Our ref: 25_30828_P

Site Location: Land off Broadgate Weston Hills
Spalding

Summary of Proposal: Rural exception site
of 24 affordable homes

Phillipa Nanson
Sustainable Development Officer
Water Management Alliance

Site Layout and Location Plan

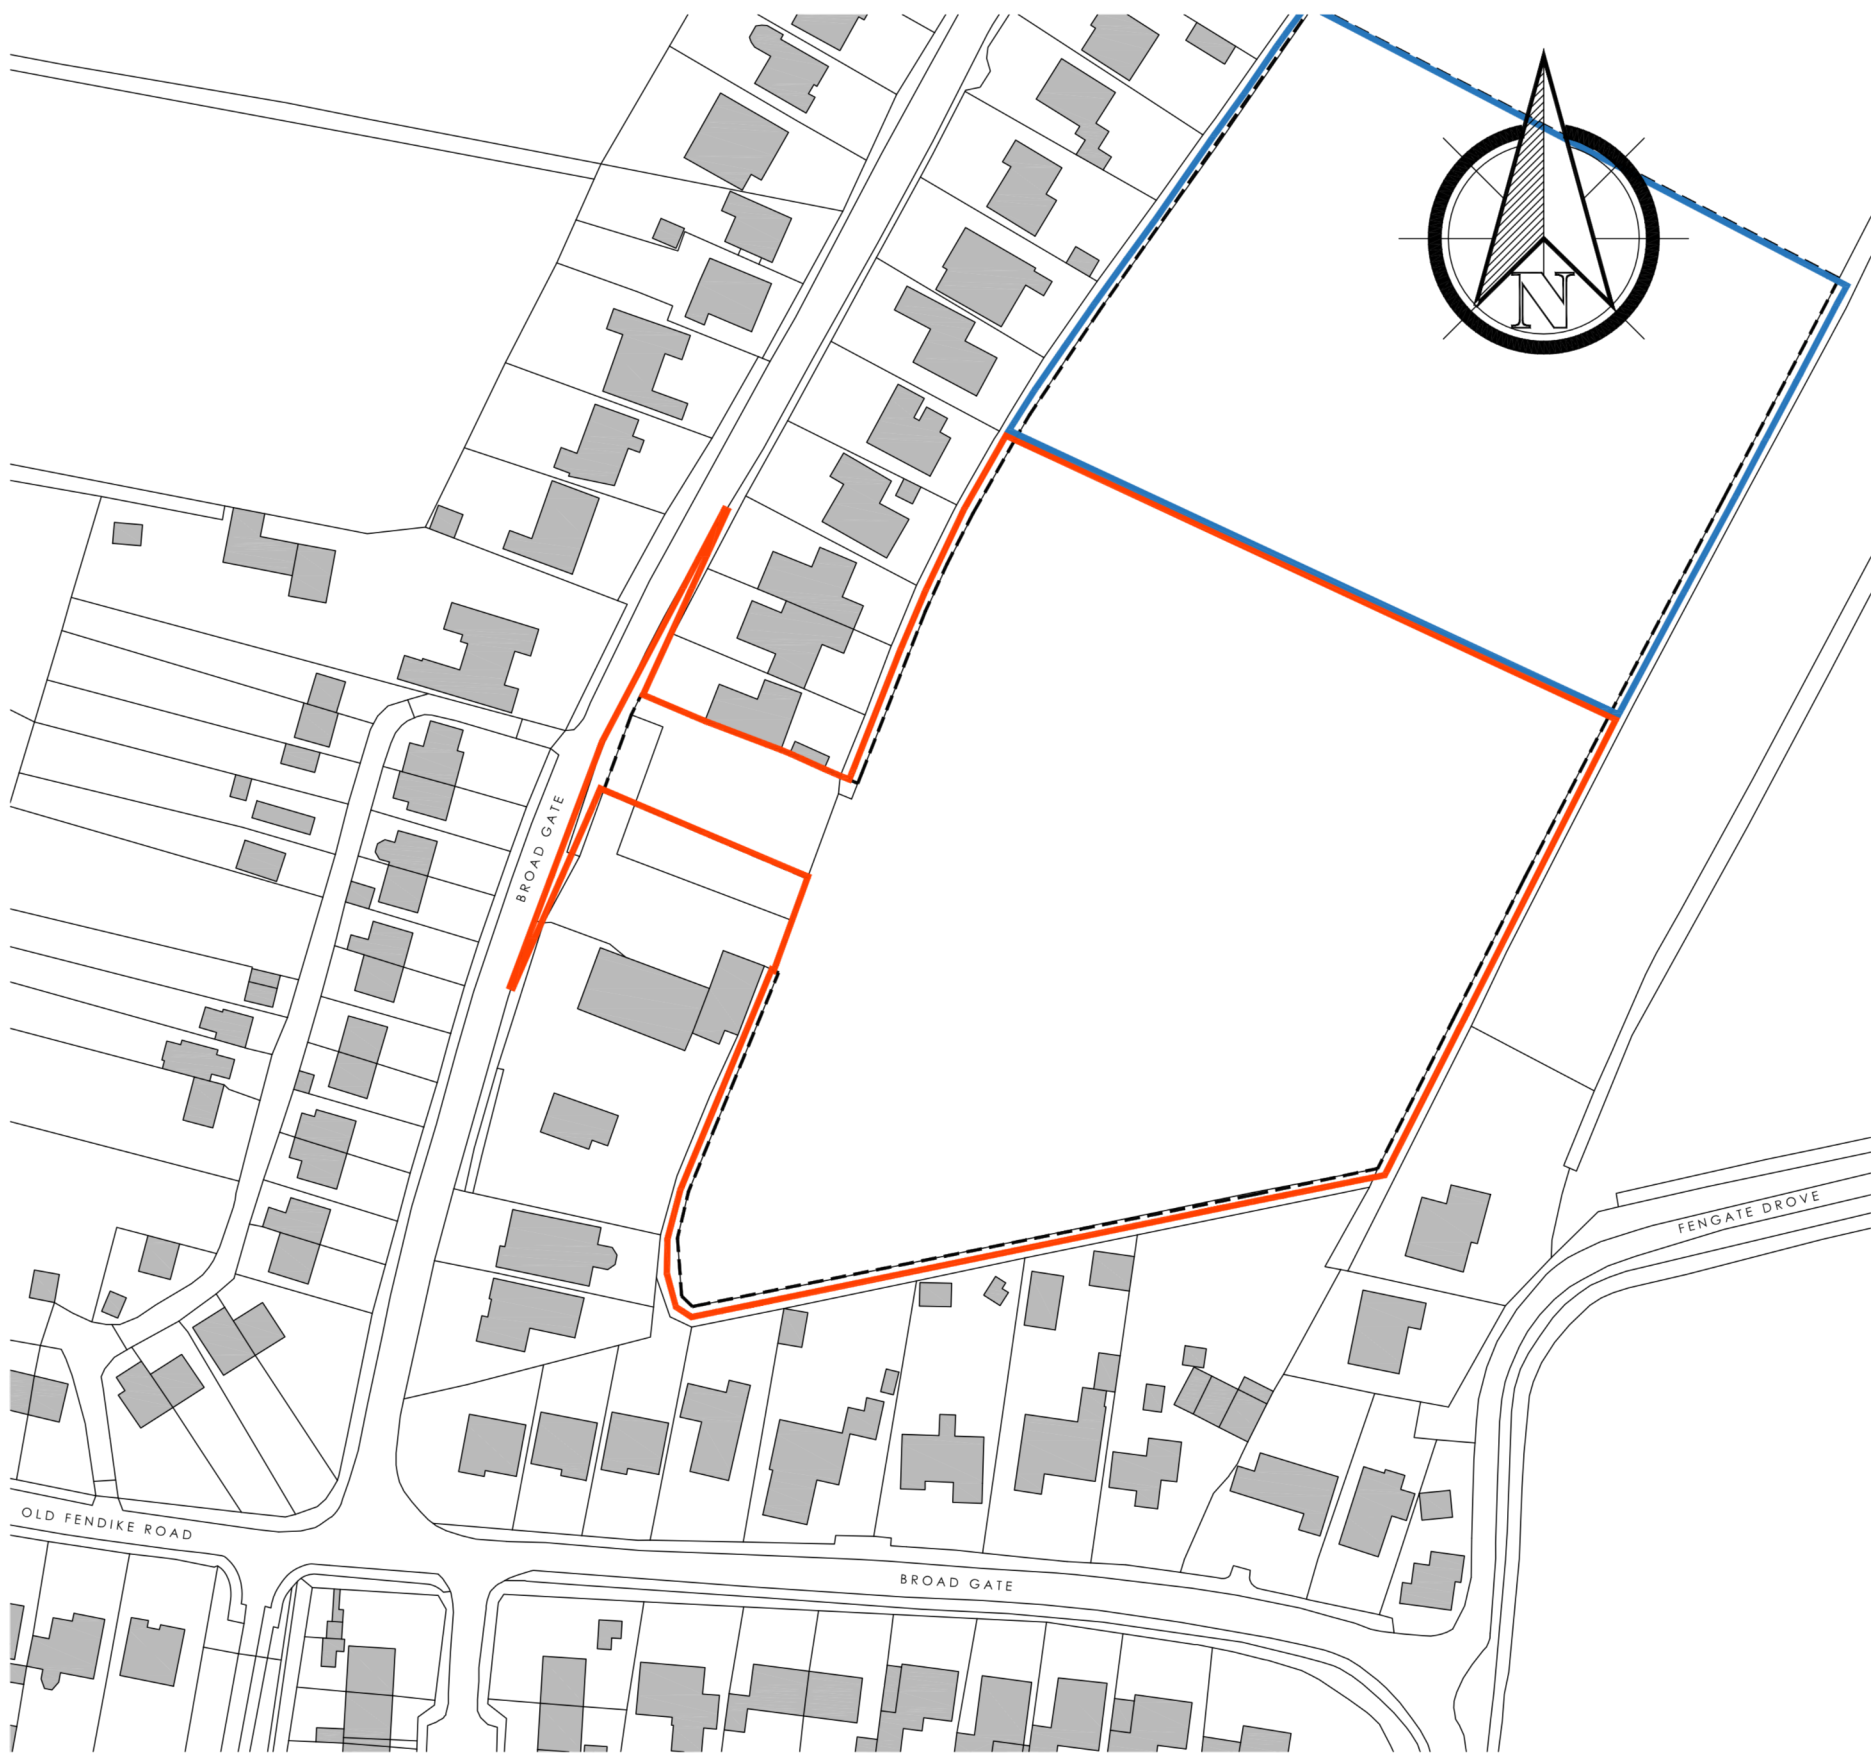
The applicant proposes to discharge surface water to a watercourse at a rate of 1l/s. I am pleased to see that the applicant has aimed to reduce the discharge to below greenfield rate. Regardless of the proposed discharge rate, this proposal will require consent under Byelaw 3, and I recommend that the applicant contacts this office to make an application for this consent at their earliest convenience. A surface water development contribution is likely to be payable as a condition of any consent granted under Byelaw 3 in line with the WMA's [Development Control Charges and Fees](#).

I note the presence of a watercourse which is not maintained by the Board (a riparian watercourse) surrounding the site boundary. Whilst not currently proposed, should the applicant's proposals change to include works to alter the riparian watercourse, or if works are proposed to alter the watercourse at any time in the future, consent would be required under the Land Drainage Act 1991 (and byelaw 4).

The Board recommends that adequate space (3-5 metres) is left flat and free from obstruction adjacent to the riparian watercourse in order to enable maintenance by future riparian owners or a designated maintenance company/contractor.
